Re: *Land rear of 25-31 Warren Road, Ickenham (access from Heythrop Drive)*
Ref:- 77265/APP/2022/2845

Further to our Client's detailed application for a residential development at the above site and your letter dated 29th September.

Floor Plans & Elevations Plot 4

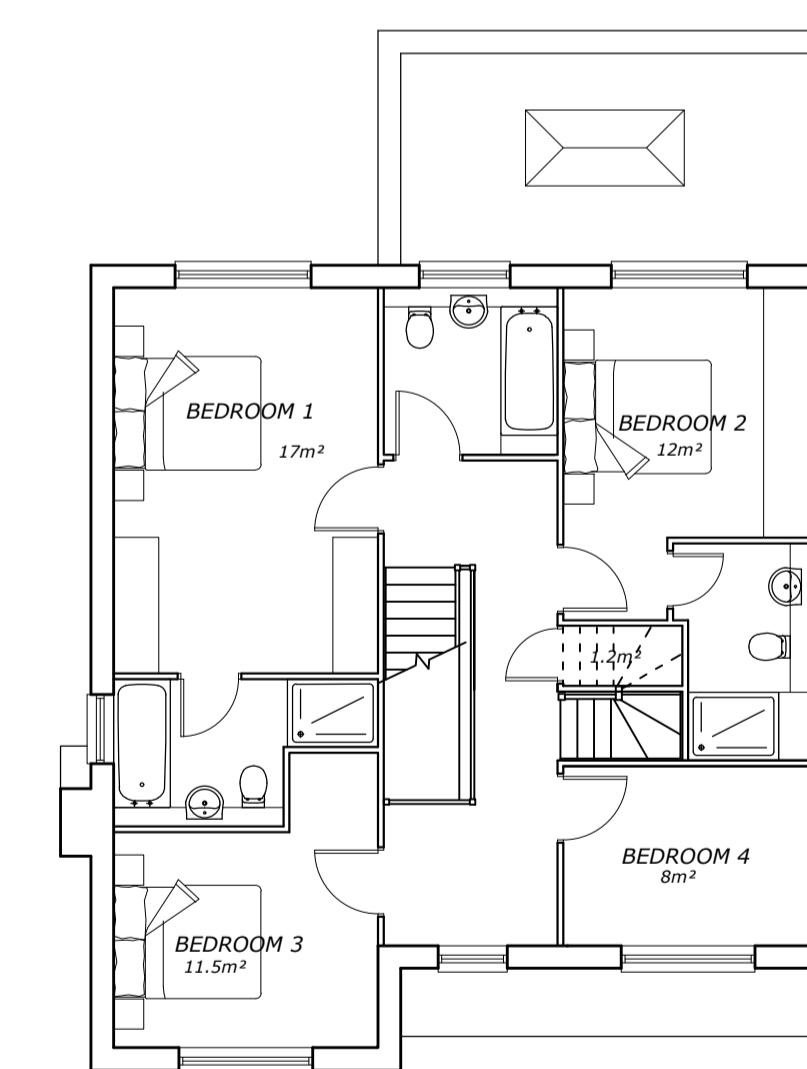
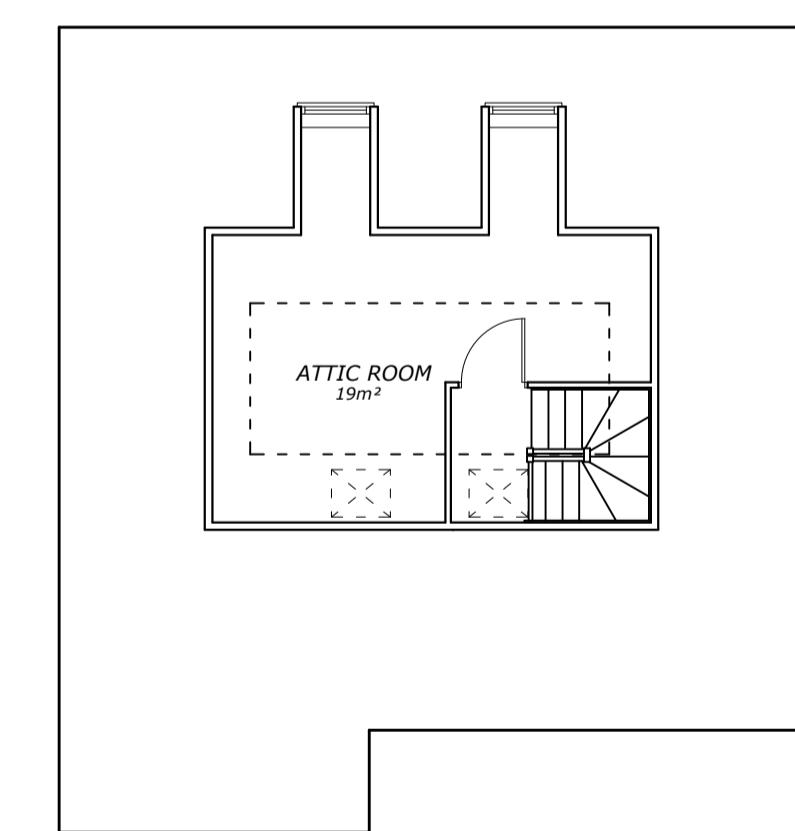
Plot 4 has one small window at first floor on the west elevation serving an en-suite shower room. It will be obscurely glazed. This is a perfectly common feature and the "perception of being overlooked" point is not accepted.

Drawing Number	22 / 3521 / 19	Revision
Date	24 / 10 / 22	
Scale	1:200 @ A1

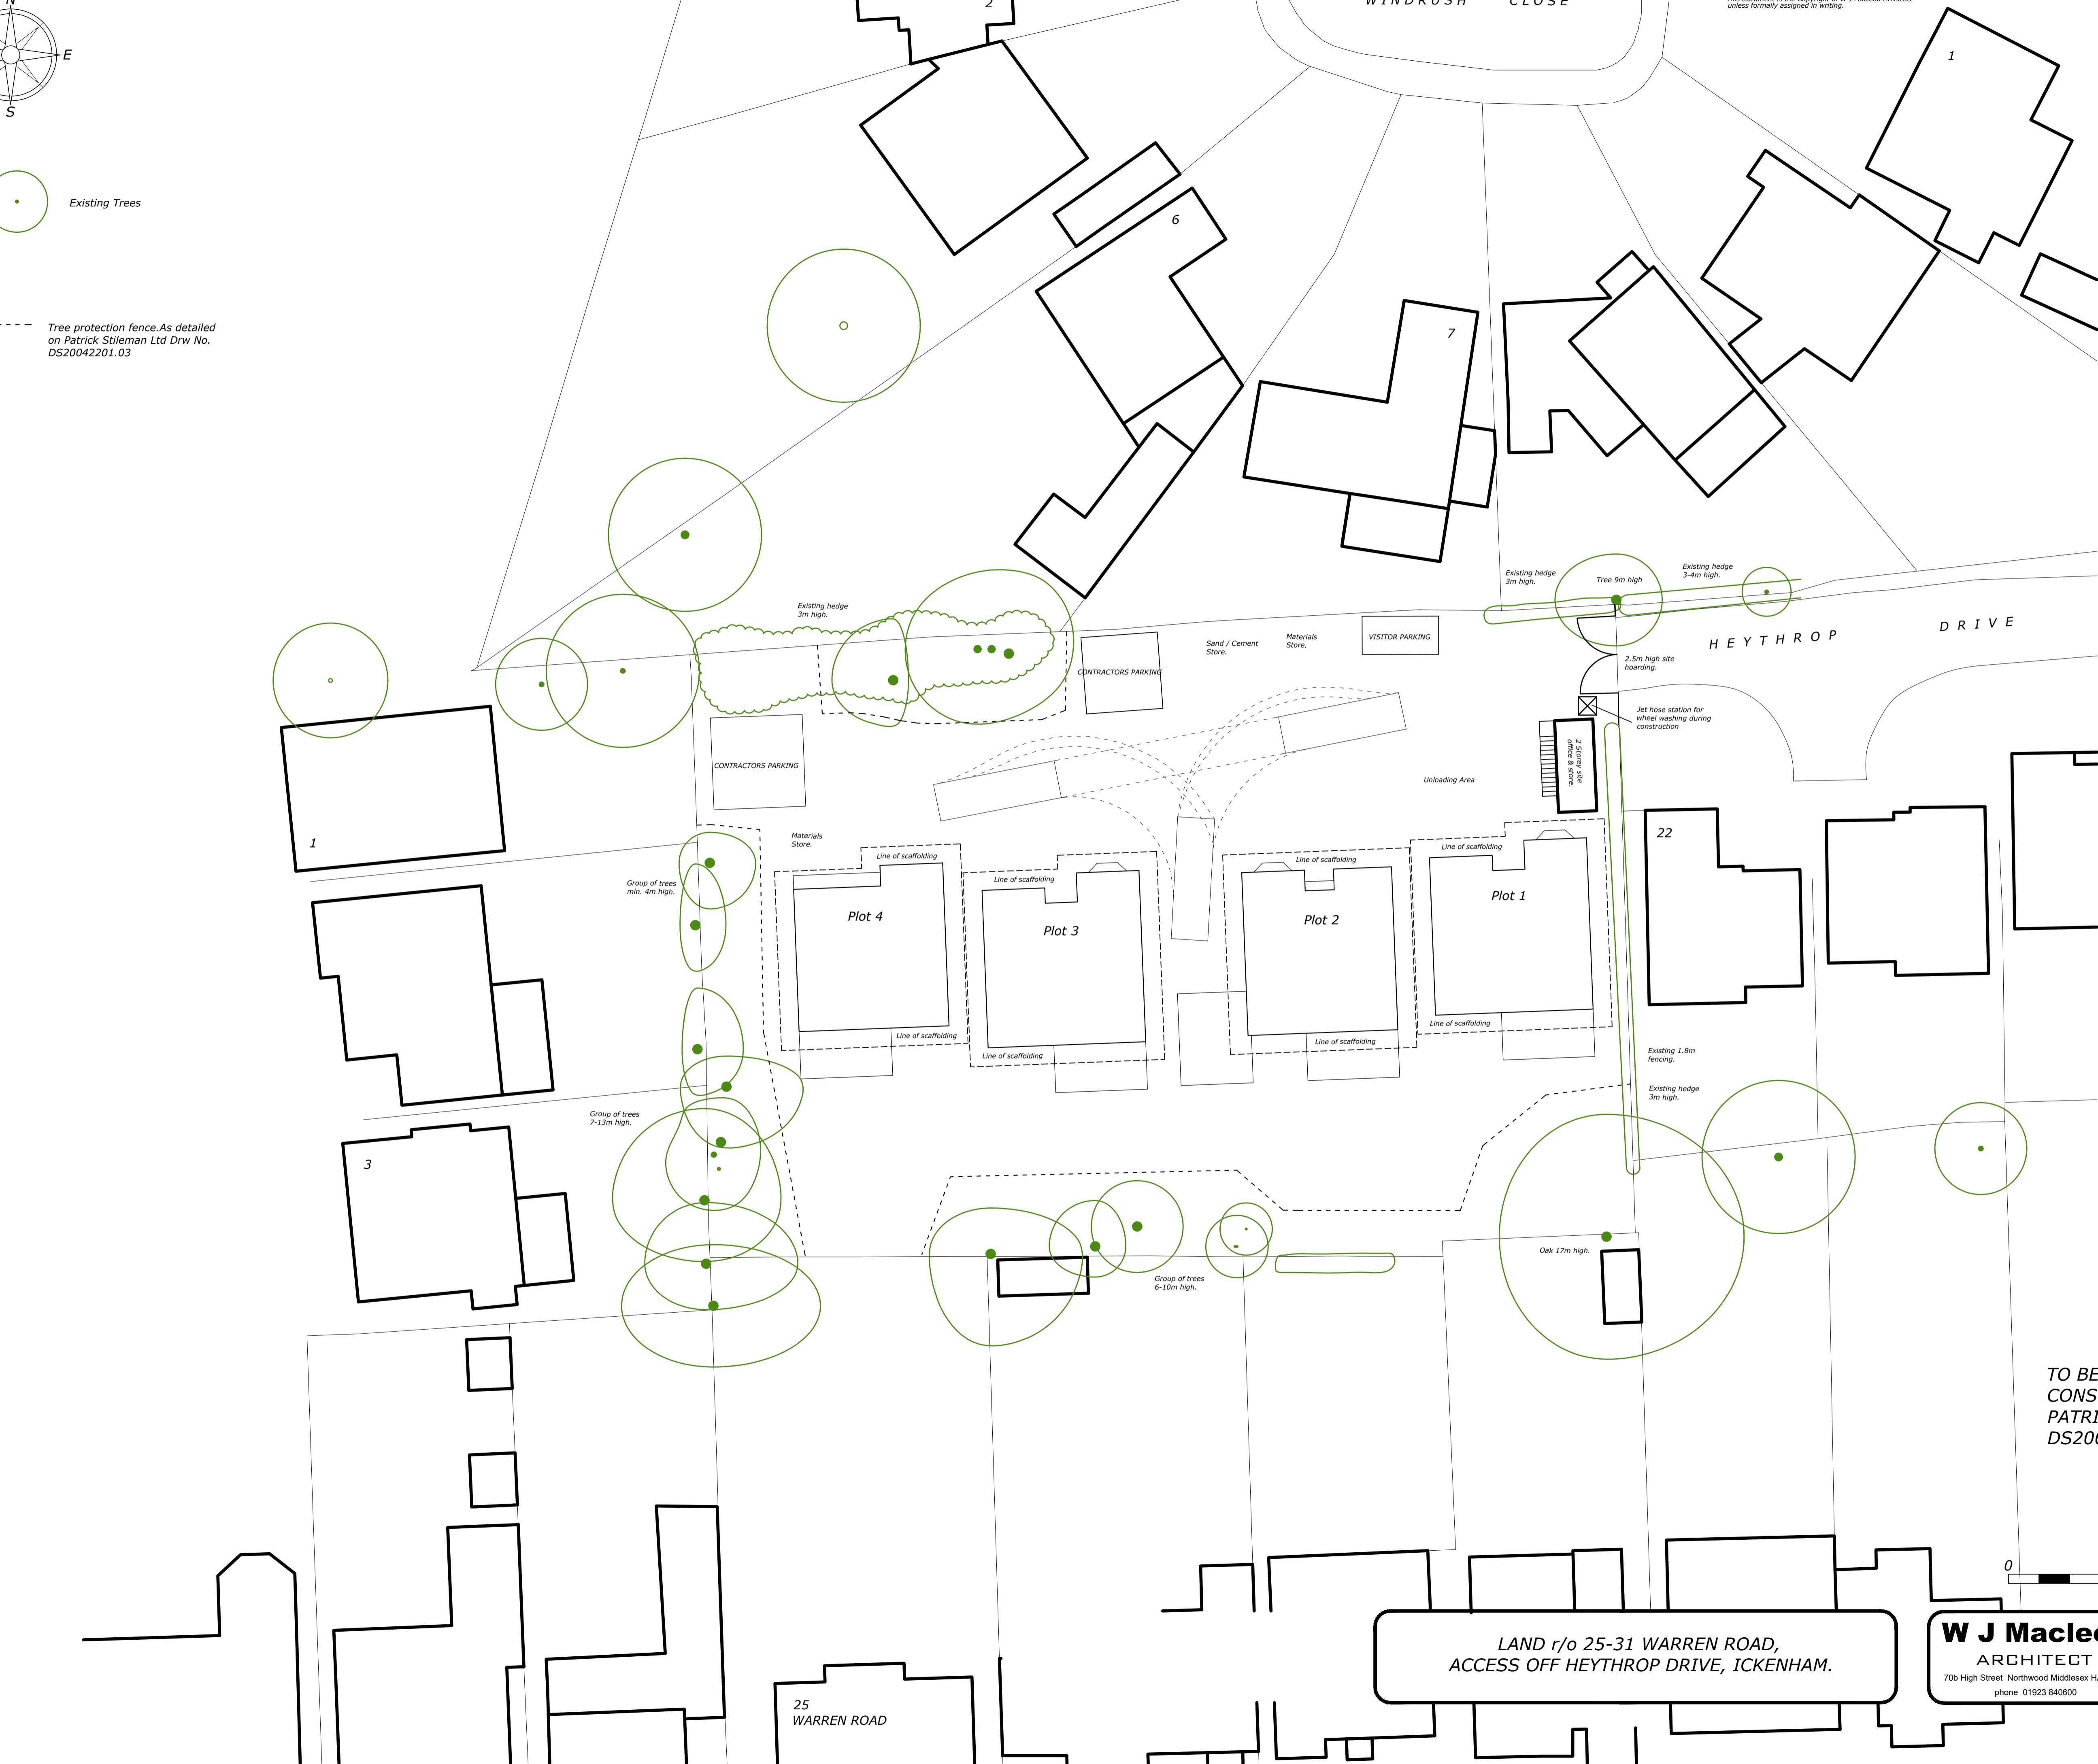
A tree report was submitted with the application; however, we note that you have requested more information in the form of method statement and tree protection plan. This is attached.
